# FALCON HIGHLANDS SOUTH FILING NO. 1

SITUATED IN SECTION 12, TOWNSHIP 13 SOUTH, RANGE 65 WEST OF THE 6TH PRINCIPAL MERIDIAN, COUNTY OF EL PASO, STATE OF COLORADO

FILE NO. 24004308-PLAT	DATE 07/10/2024	DRAWN BY MSF	CHECK BY PSJ	JOB NO. 24004308
REVISIONS				
1ST SUBMITTAL 08/16/2024

SITUATED IN SECTION 12, TOWNSHIP 13 SOUTH, RANGE 65 WEST OF THE 6TH PRINCIPAL MERIDIAN,
COUNTY OF EL PASO, STATE OF COLORADO

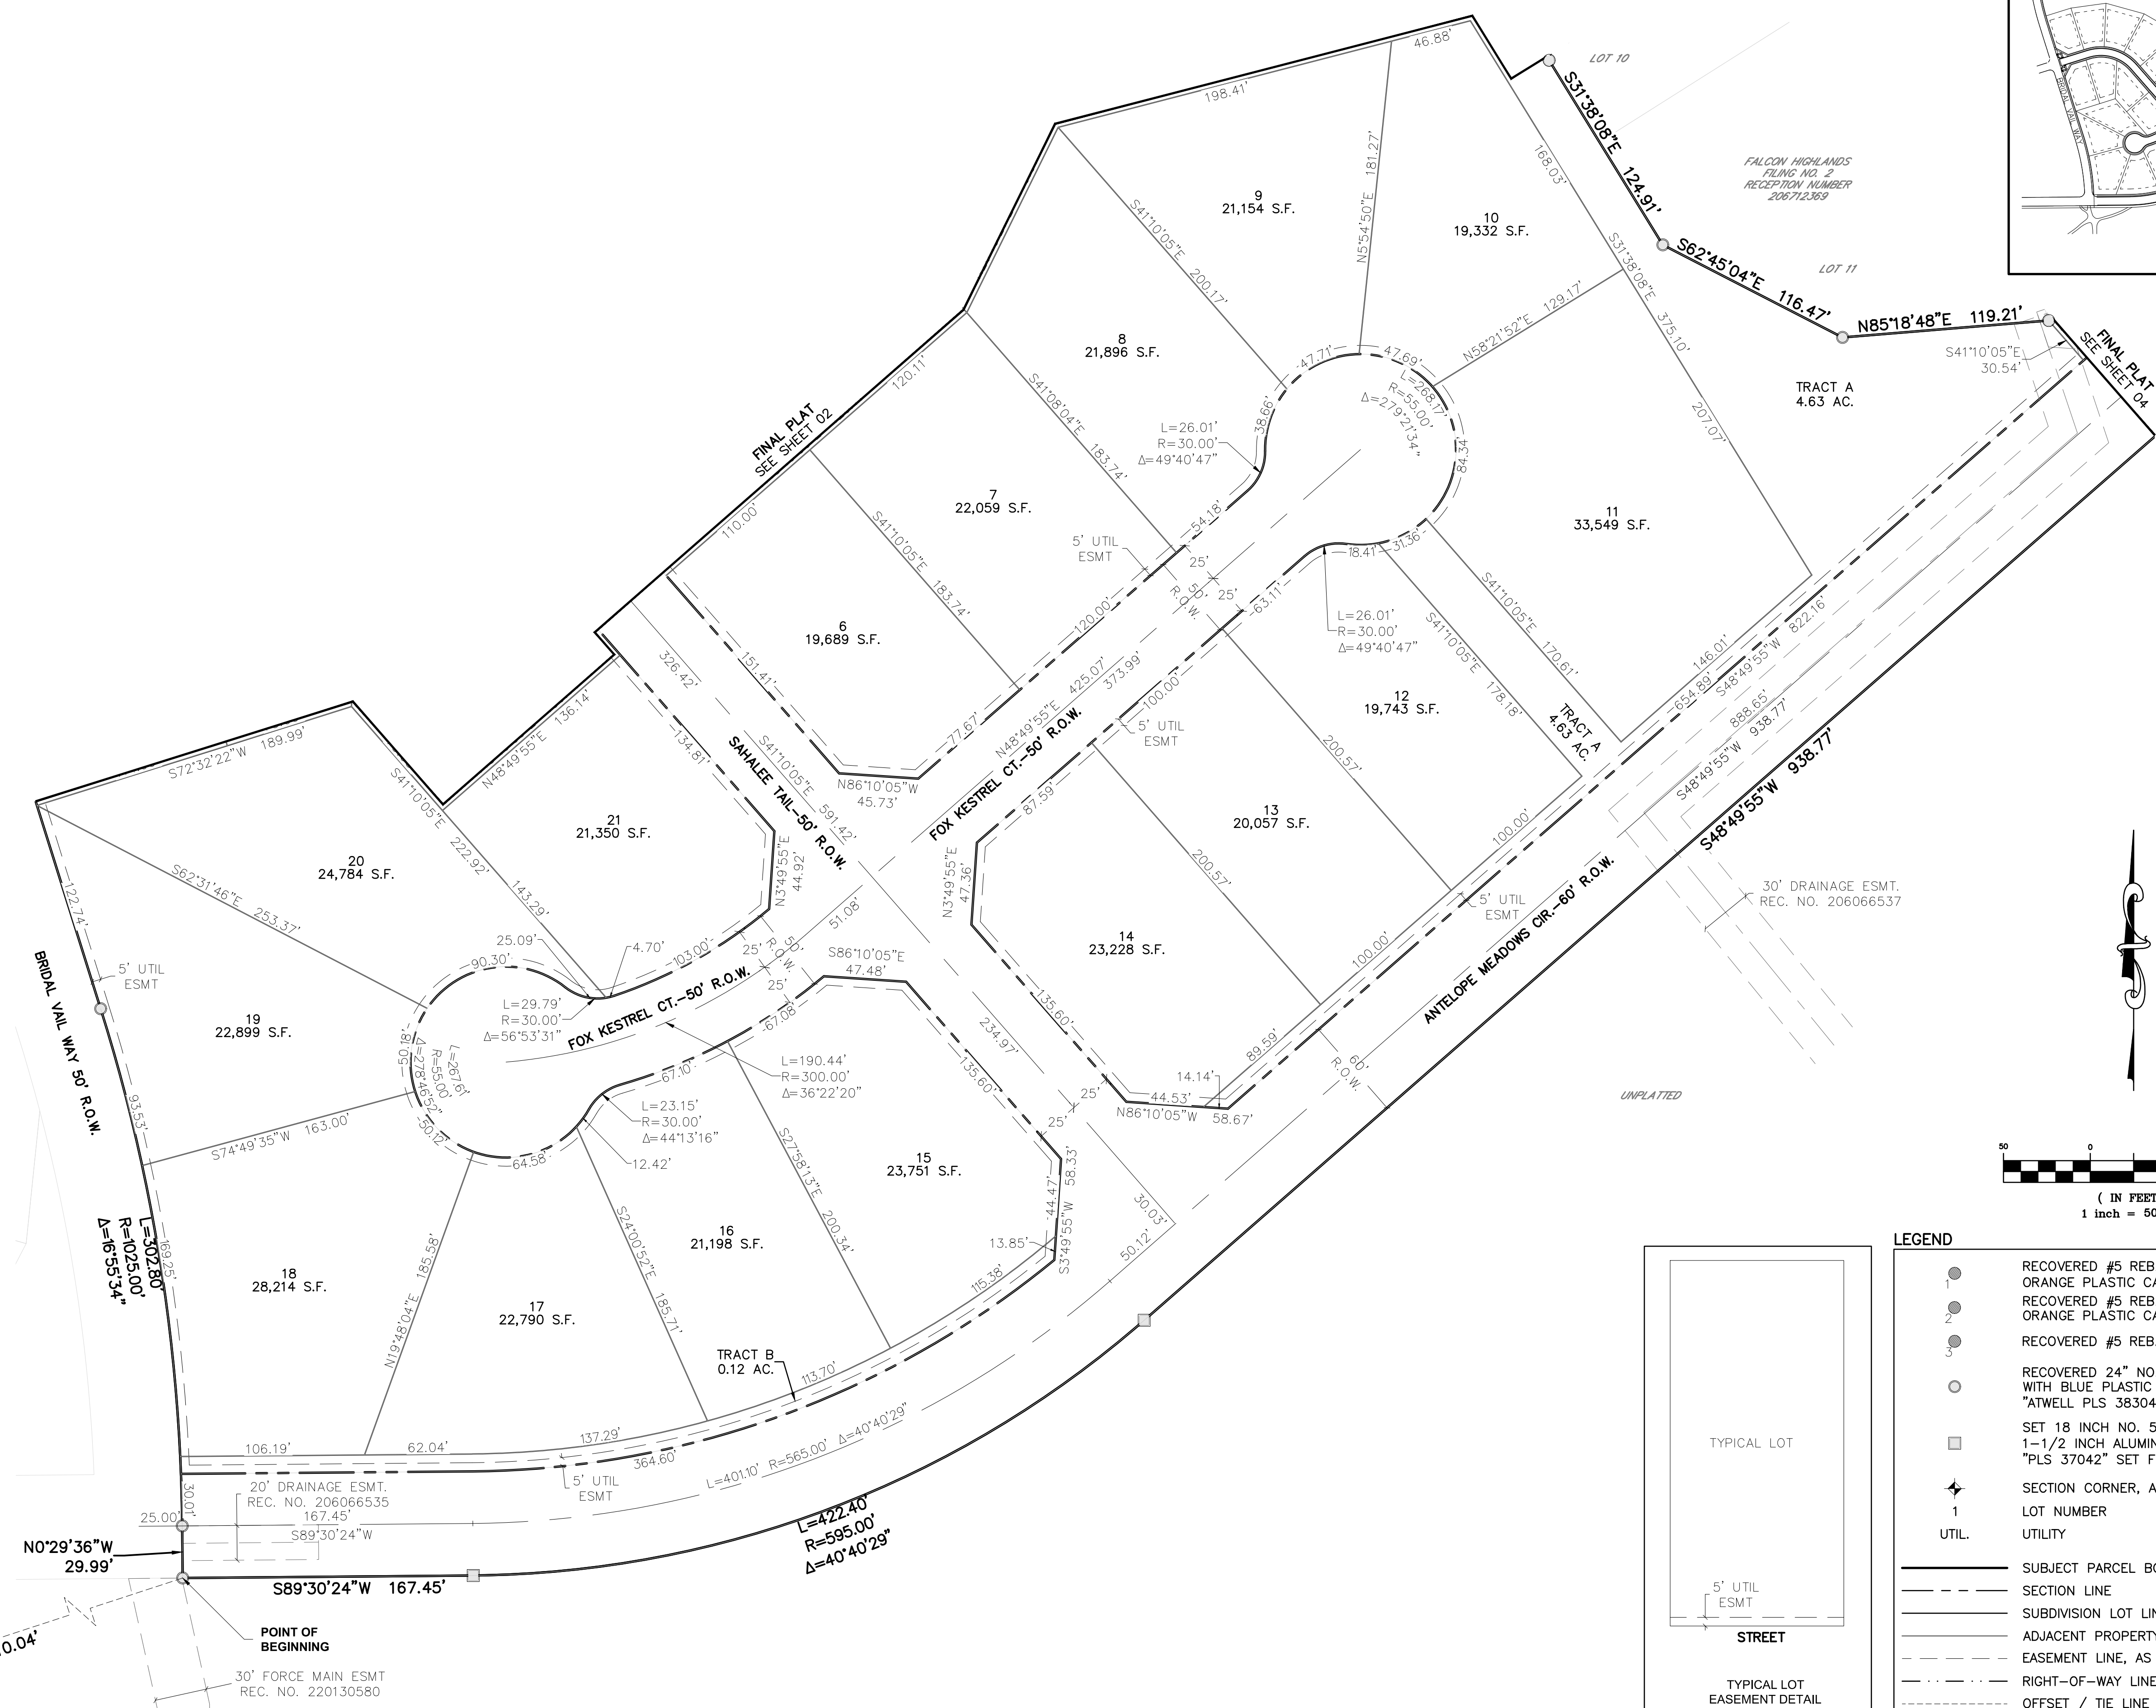
Please update each lot to read: "lot 1", "lot 2", etc.

anything depicted on the plat that is "not apart of this subdivision" shall have that statement

This key map does not match what is being shown on this page of the plat, please adjust and show all easements on the lot (side and rear)

All adjoining properties shall be depicted with dotted lines

TYP: Please update the 5' easement types to "Public Improvement Easement" as shown in our standard details

Lot sizes and configurations for this plat are different from PUD, please explain or adjust to match

This key map does not match what is being shown on this page of the plat, please adjust and show all easements on the lot (side and rear)

TYPICAL COMMENT FOR ALL EASEMENTS  
Please ensure that easements are shown properly. Also, please use this Plat as an opportunity to remove unneeded easements (such as locations where land will become EPC ROW)

Lot has been added as requested.

Not a part of this subdivision has been added as necessary.

Keymap is no longer necessary and has been removed.

Adjacent property lines types have been revised to a dotted line.

Per the comment on sheet one, the easement is now 10' wide and called public utility/drainage easement.

Lot sizes have varied slightly from the approved PUDSP due to the detailed engineering and plat production of the site. The general lot size and layout are still in conformance with the PUDSP.

Keymap is no longer necessary and has been removed.

Center lines of easements have been removed for clarity. Easements are now shown as being vacated. Please see sheet 03 for detailed information for partially vacated easements.
